State Significant Development SSD 6880 – Construct and operate resource recovery facility – 90 Gindurra Road, Somersby

Our ref: DOC19/509616

State Significant Development SSD 6880 – Construct and operate resource recovery facility – 90 Gindurra Road, Somersby

The EPA has now finalised a review of the surface water information provided in the Environmental Impact Statement and requires the following additional information prior to issuing GTA's. The additional information is outlined below.

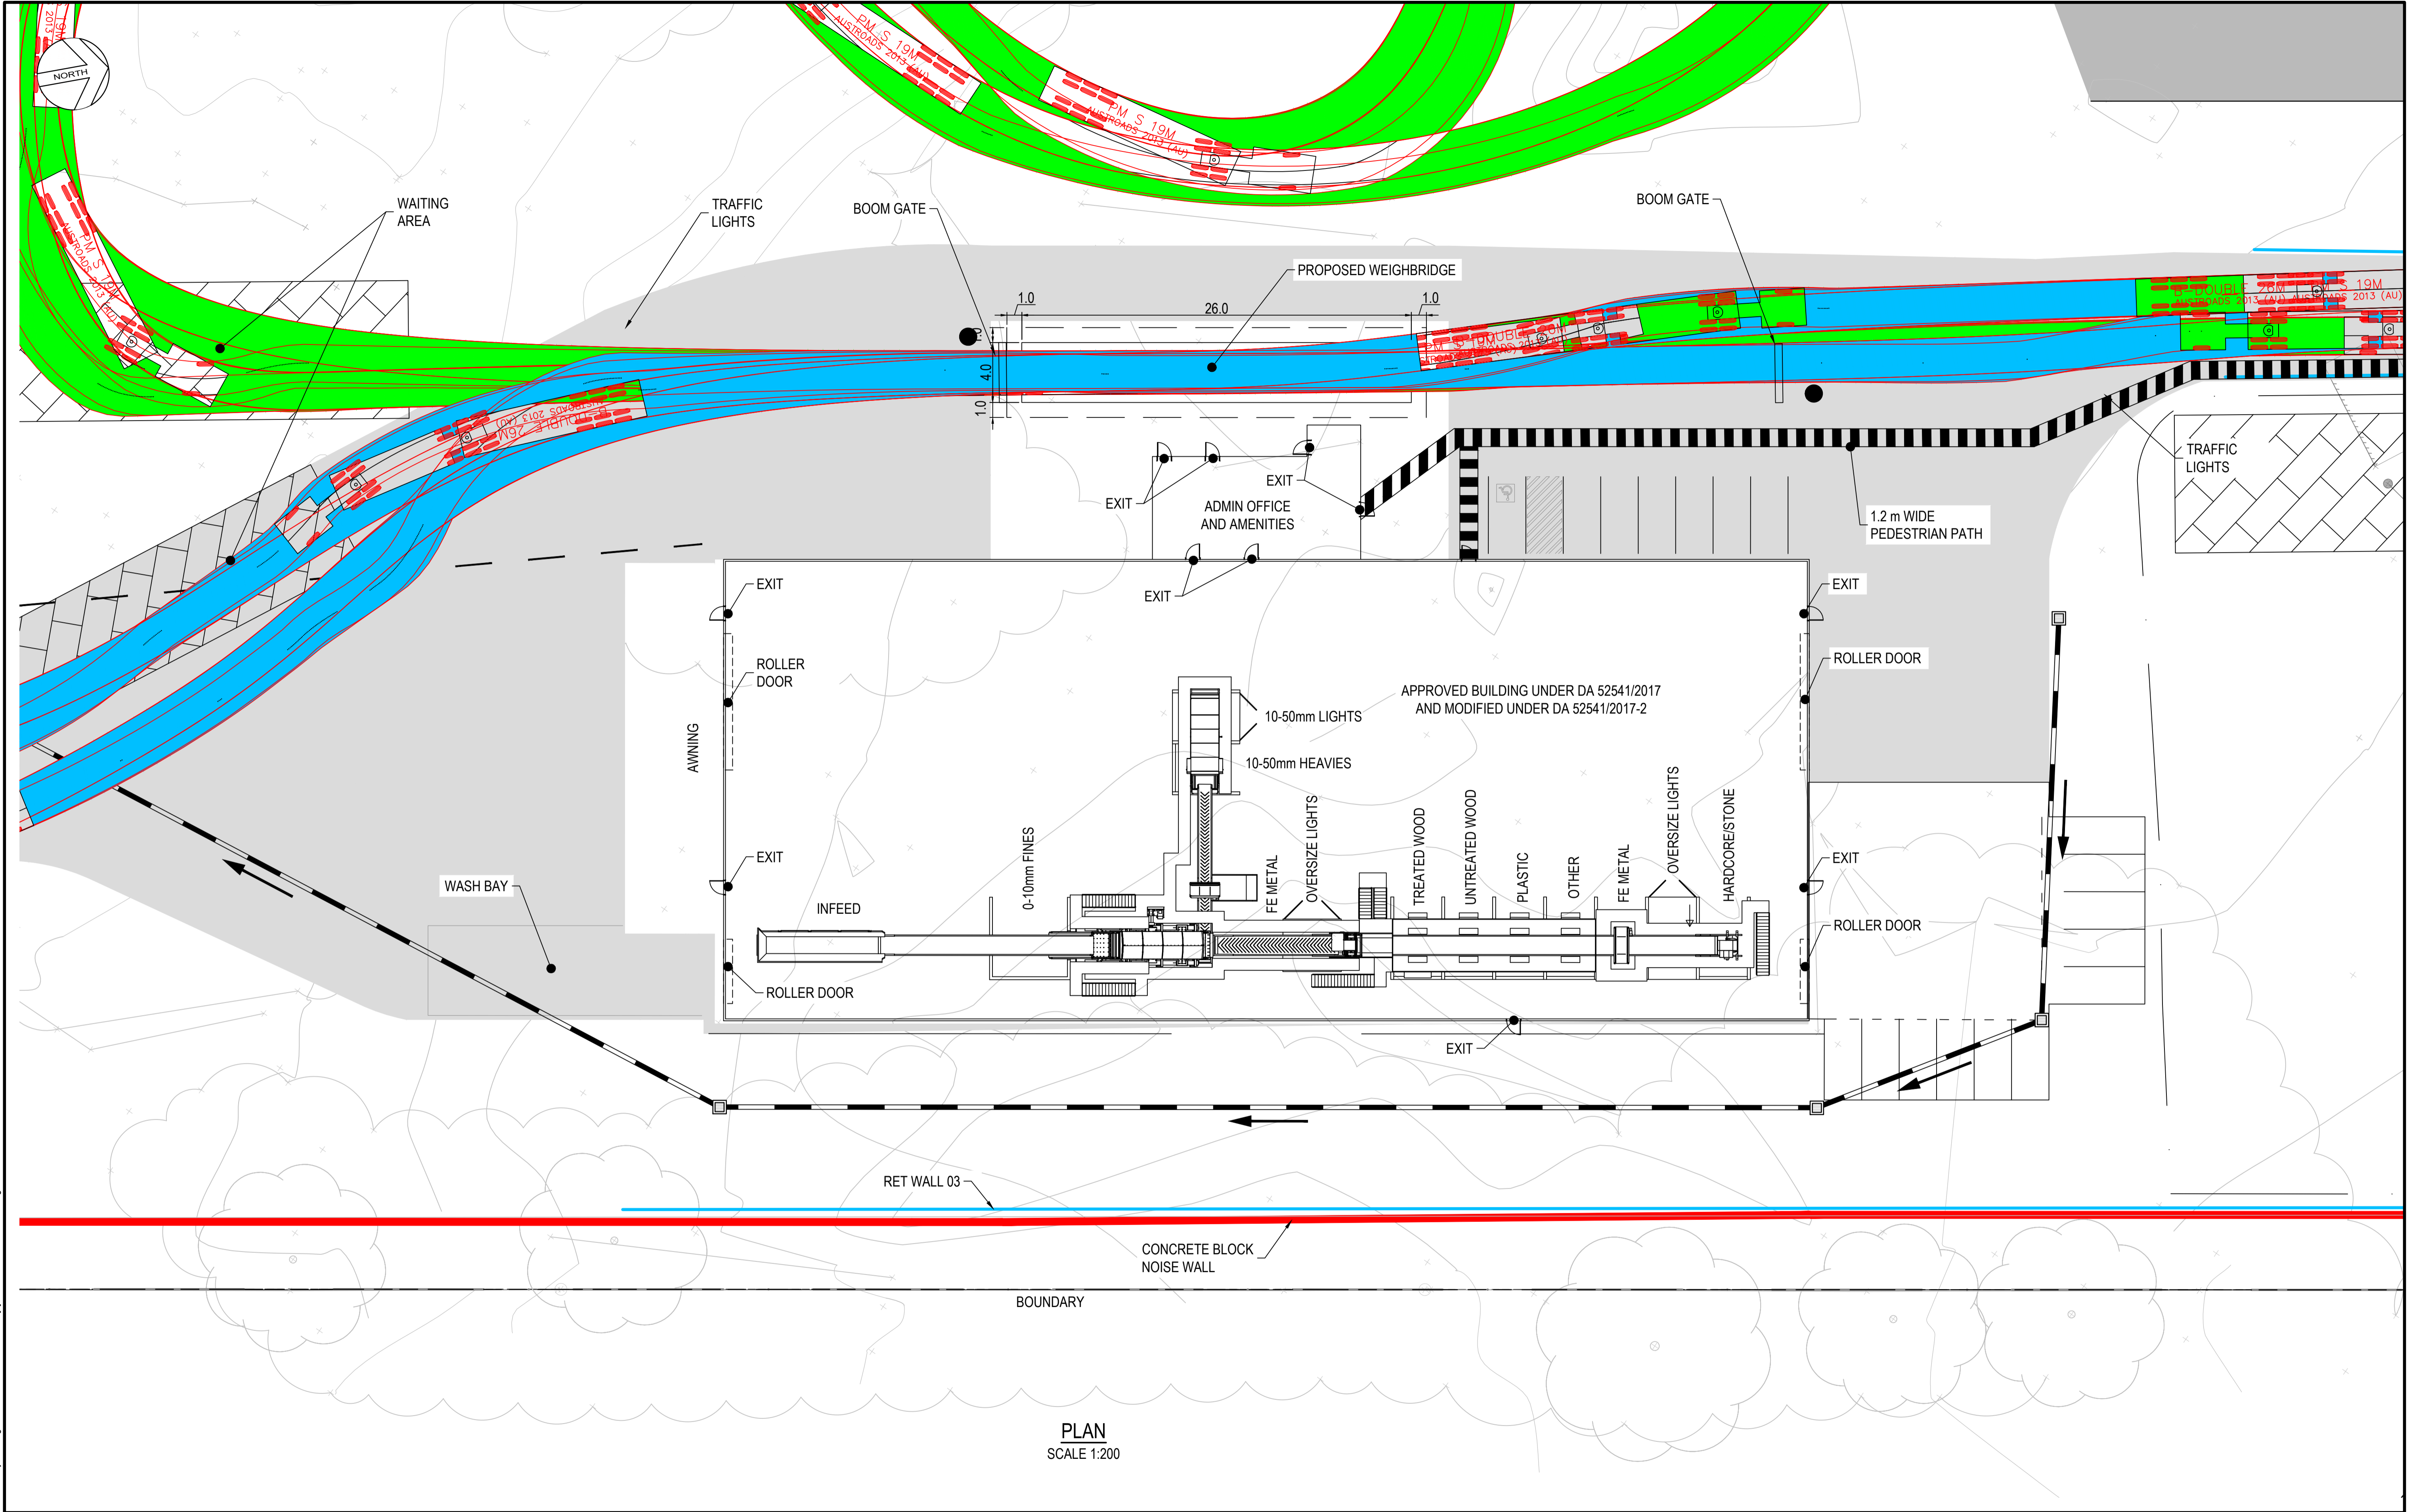
The EIS proposes a sediment inlet pond to be used at the entry to the proposed pond storage to capture sediment from site runoff. The pond is proposed to consist of a permanent pool for re-use purposes and an on-site detention component designed to meet Council requirements. As noted

The stated overflow frequency of “about 35” overflows per year on average is not consistent with best practice guidelines for clean sediment containment e.g. 6–8 spills/year (Blue Book Volume 1 site, > 6 months, 80th percentile); or 2–4 spills/year (Blue Book Volume 2, > 6 months, 90th percentile for managing clean sediment at waste landfills and mines and quarries).

It is noted that the EIS states that overflows are directed to a Jellyfish sediment-treatment device and Appendix I states that overflows occur over the spillway from the pond. It is not clear what proportion of discharges occur via the proposed Jellyfish filter versus the overflow structure, or the height of the Jellyfish inflow and outflow levels compared to the overflow structure level.

Sediment basins are proposed to be cleaned out when 60% full of sediment. The overflow frequency when the ponds are up to 60% filled with sediment are also not adequately assessed.

- Revises the water balance assessment and, as a starting point, relate all references to the Blue Book Volume 2E.
- Provides an equivalent environmental outcome for sediment, Blue Book Volume 2E, at a minimum, and any additional risks of sediment attached pollutants and dissolved contaminants should be accounted for through either additional capture and treatment or other mitigation measures such as at-source controls.

- provide the performance of the proposed “Jellyfish” treatment system, including:
 - TSS concentrations that can be achieved over the life of the maintenance schedule
 - the percentage of flows that are treated through the device verses the percentage that may bypass the treatment device
 - the storage levels at which discharges occur through the Jellyfish filter verses storage levels that may cause overflow.
